**Pacific Brook Christian School, Muswellbrook (SSD-16858710)
Response to Submissions**

ATTACHMENT 1

Pacific Brook Christian School FIA

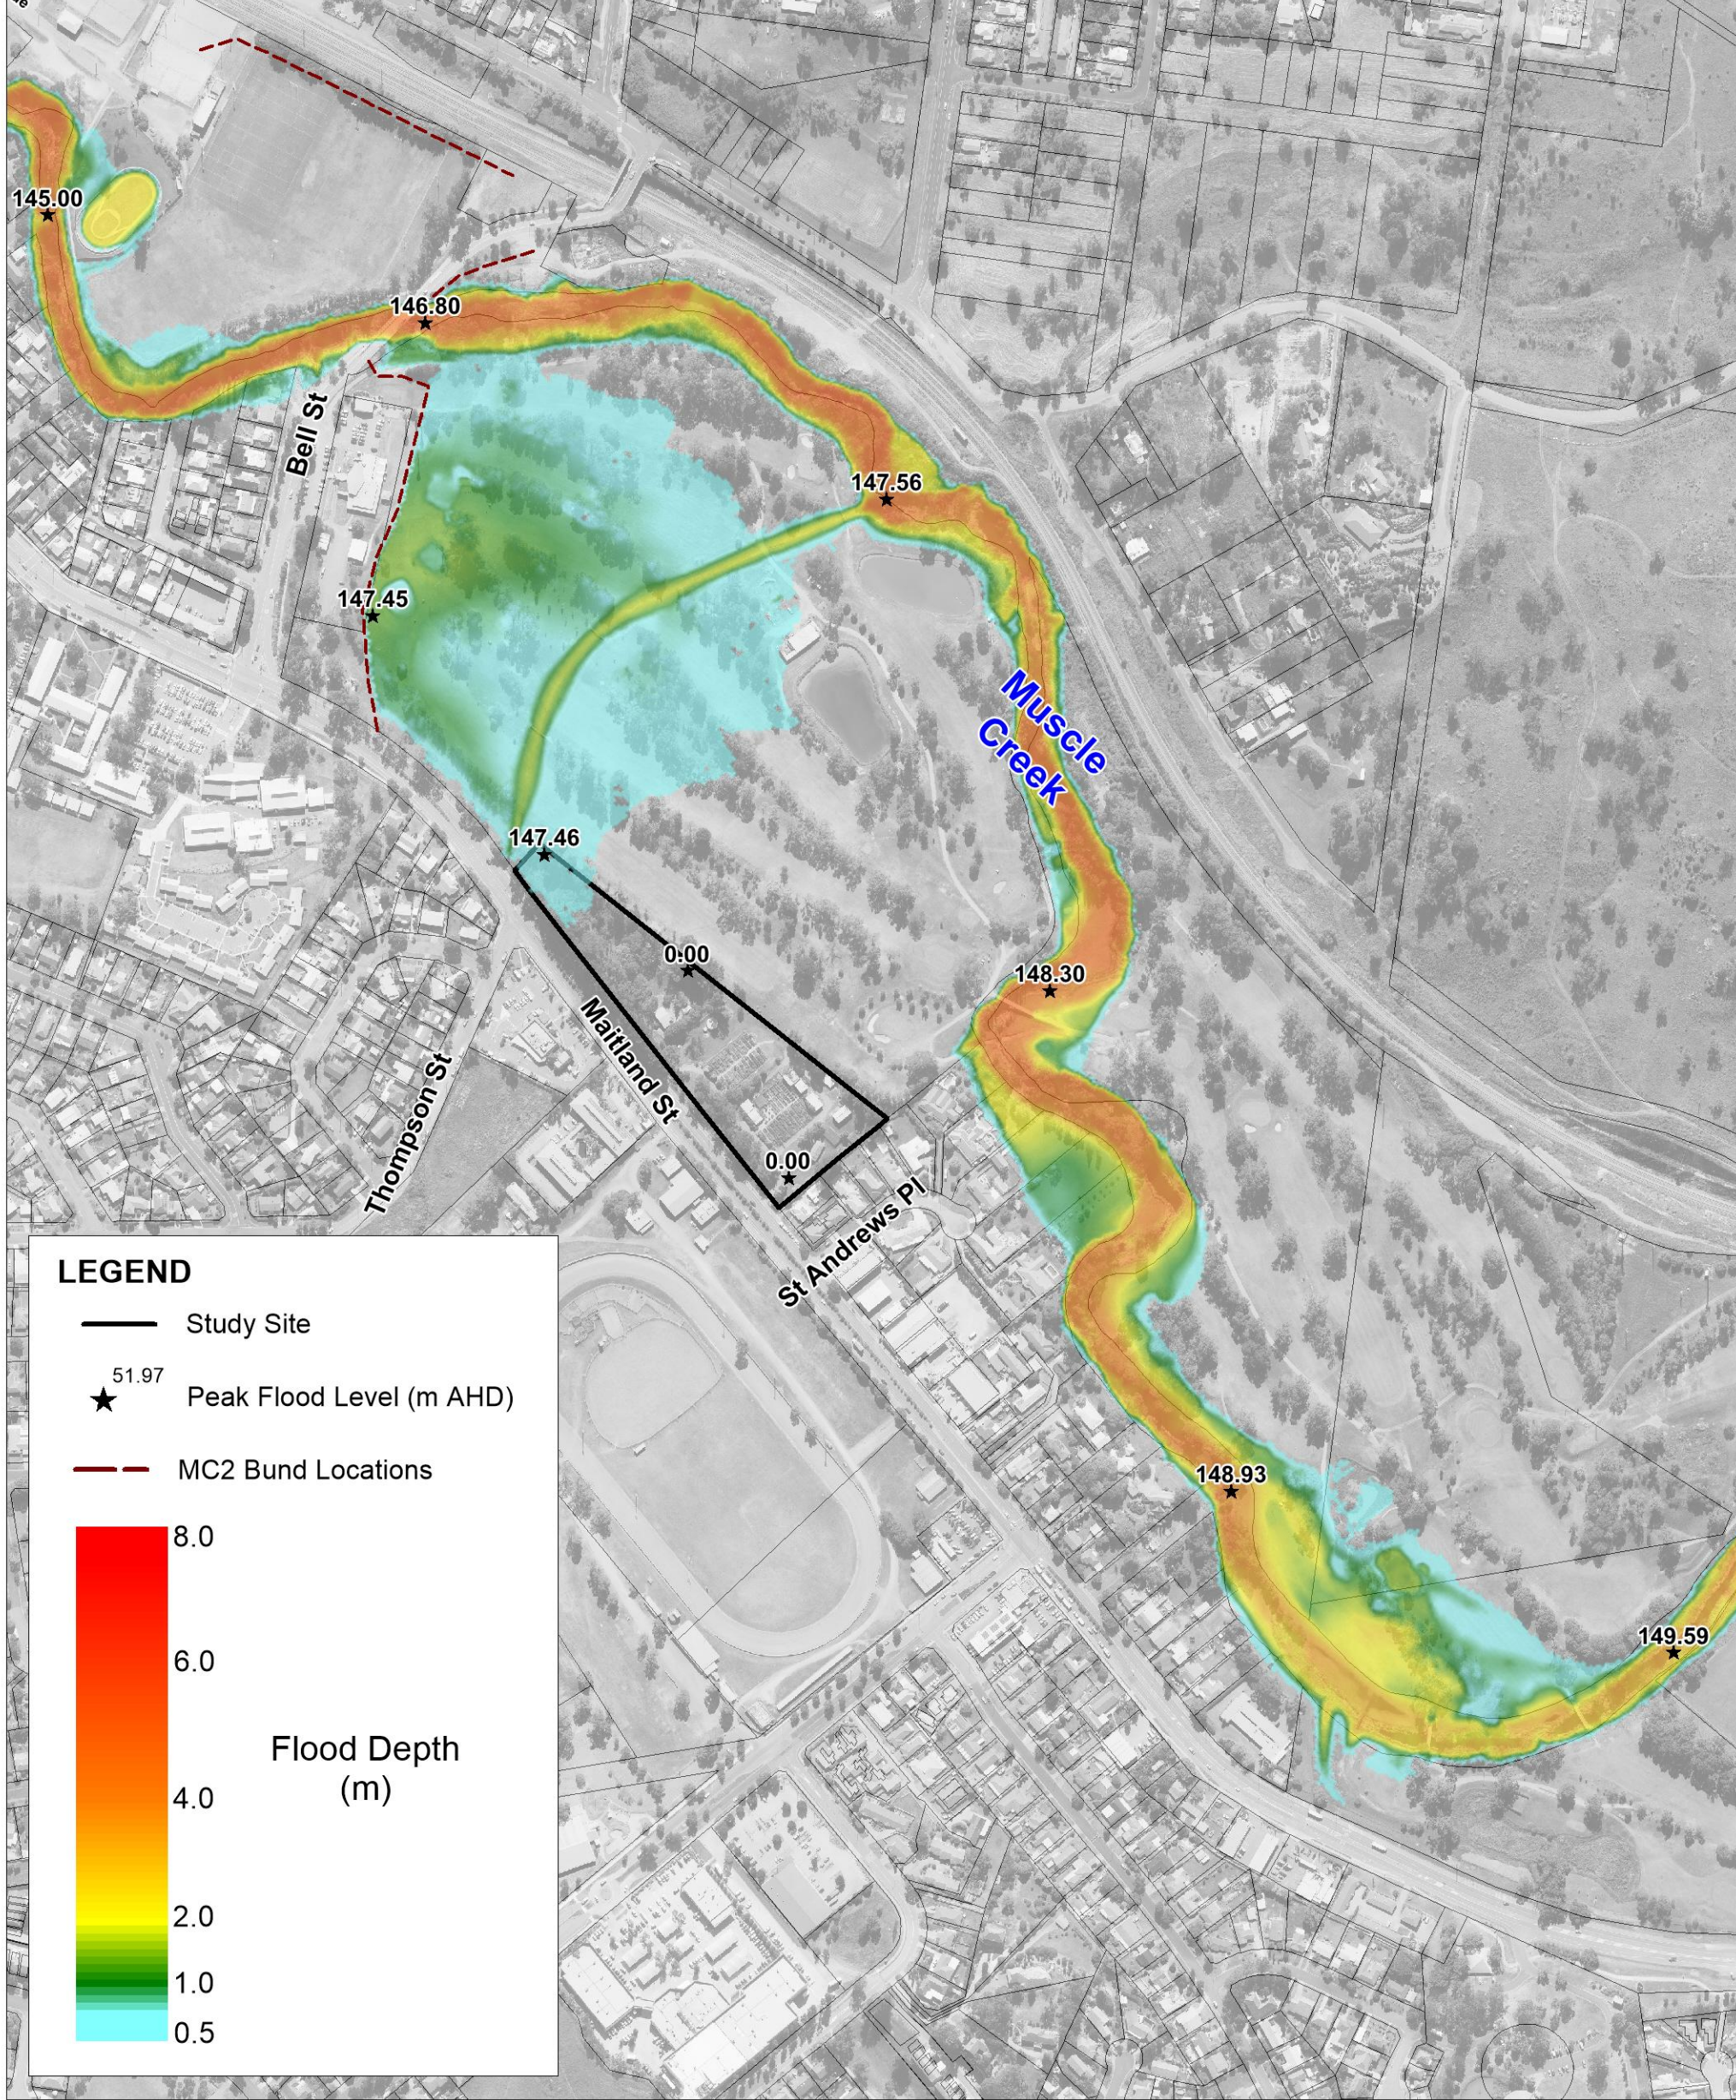
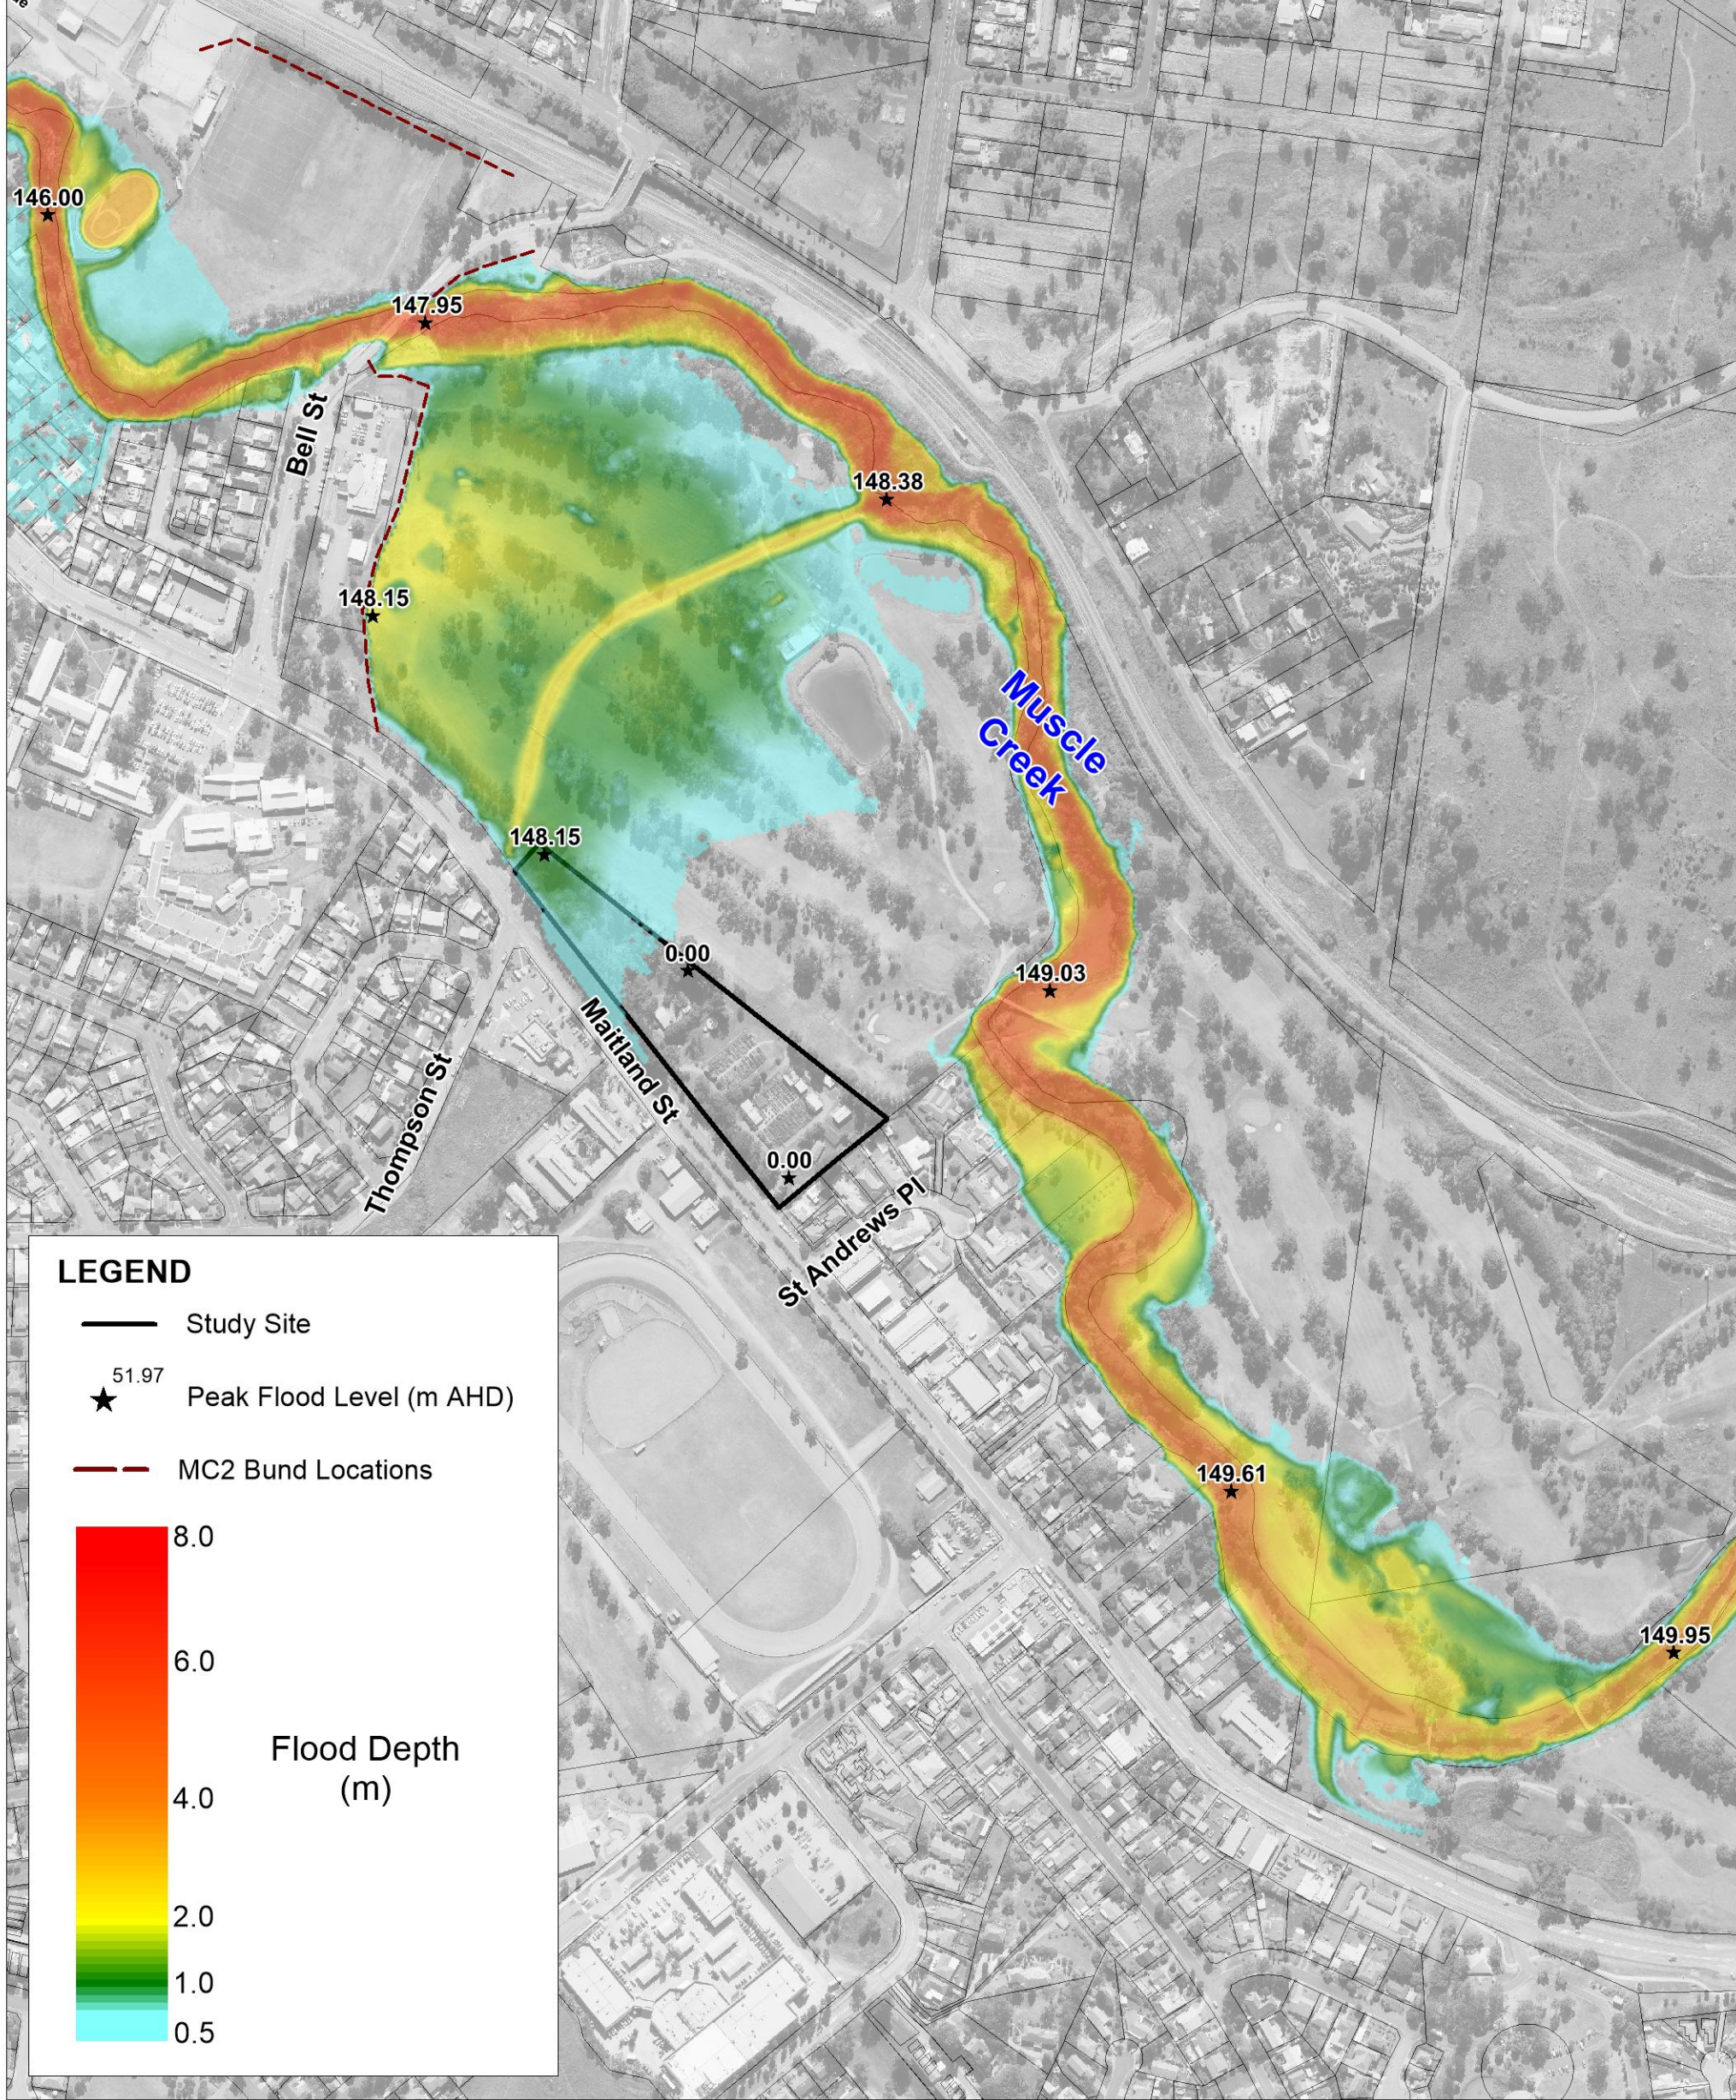
- Biodiversity and Conservation Division (BCD) have reviewed the proposal and raised substantial concerns with regard to flooding within the site. The Department shares the concerns of the BCD and requests that you amended your flooding report and respond to the comments raised by BCD.
- Additionally, the potential effects of climate change, sea level rise and an increase in rainfall intensity has not been adequately assessed. Please provide a more comprehensive flood assessment which addressed these impacts.
